13th August 2018

TALLAWONG STATION SOUTH - STAGE 1 SSD APPLICATION (SSD 9063)

The Government Architect NSW has been asked to provide independent design review and advice on State Significant Development application SSD 9063. Please find our response below.

Figure 7: Solar analysis showing overshadowing from buildings mid winter 9am to 2pm.

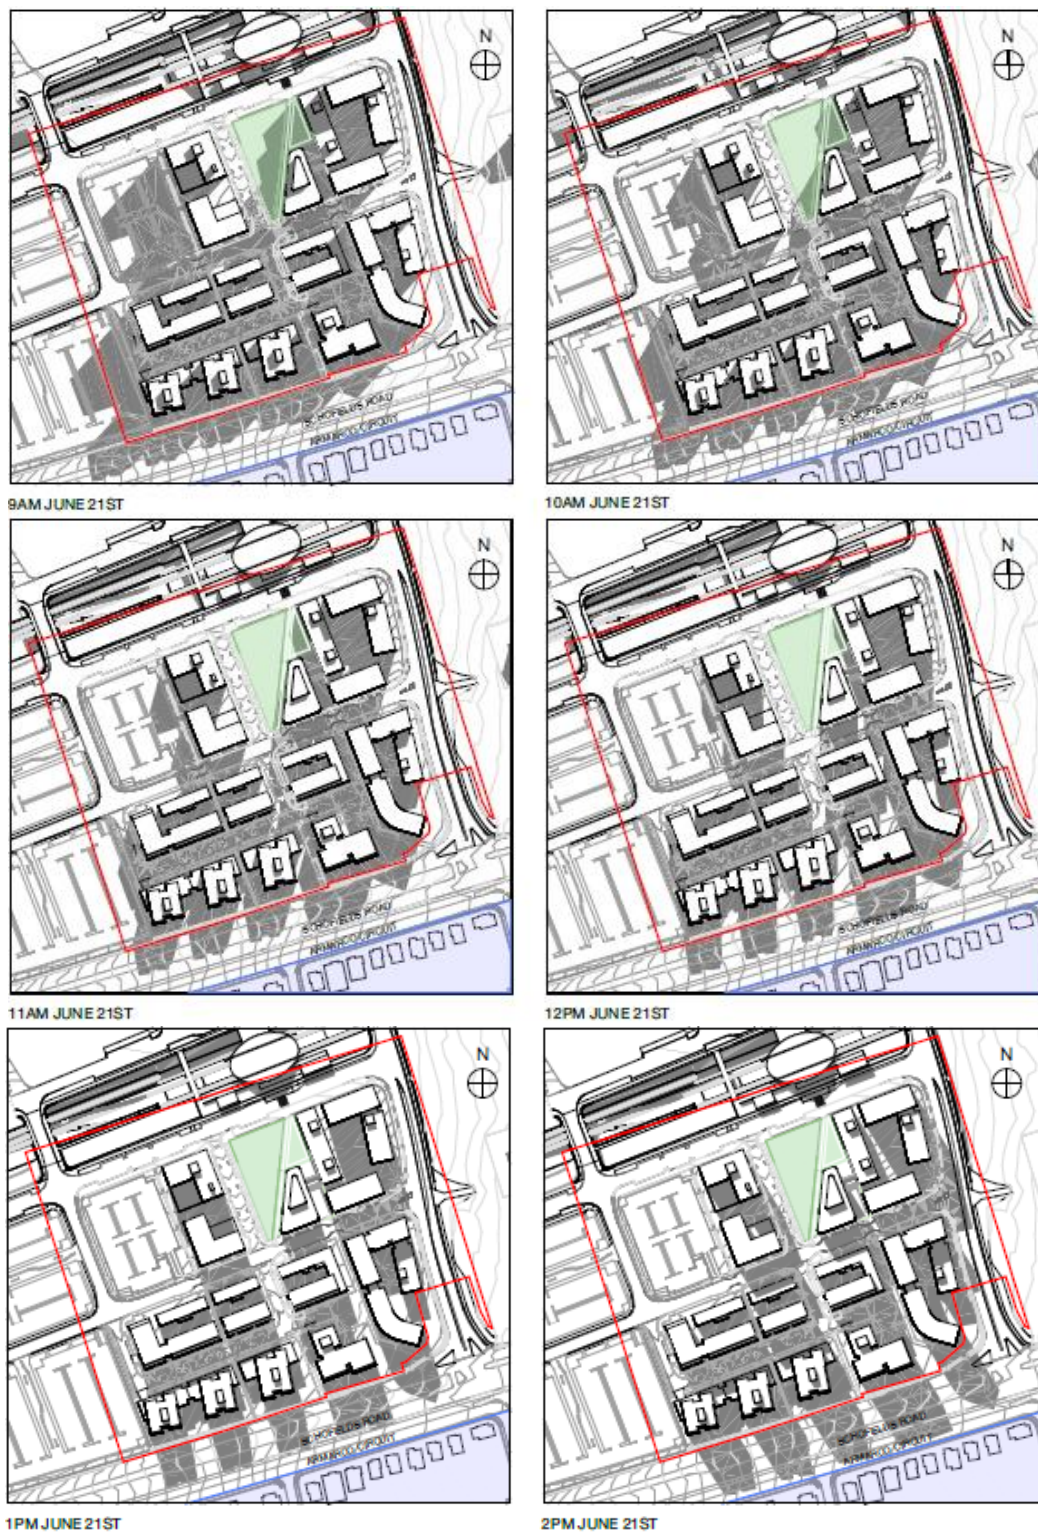
The overshadowing diagrams indicate that the large open space is minimally affected during mid-winter. This is supported. However, the other two plazas – the retail courtyard and the Cul-de-Sac plaza, and key residential streets appear to be excessively overshadowed on March 21 and June 21. This is not supported.

Details regarding the function of the public spaces was requested. The proposal addresses this question sufficiently. Notwithstanding this, over-shadowing of

spaces will compromise the amenity of these spaces. This requires further consideration.

1. Revisit density, bulk and scale to address the overshadowing issues of the two plazas and surrounding streets;
2. Establish stronger connections to surrounding green infrastructure as part of a holistic concept;
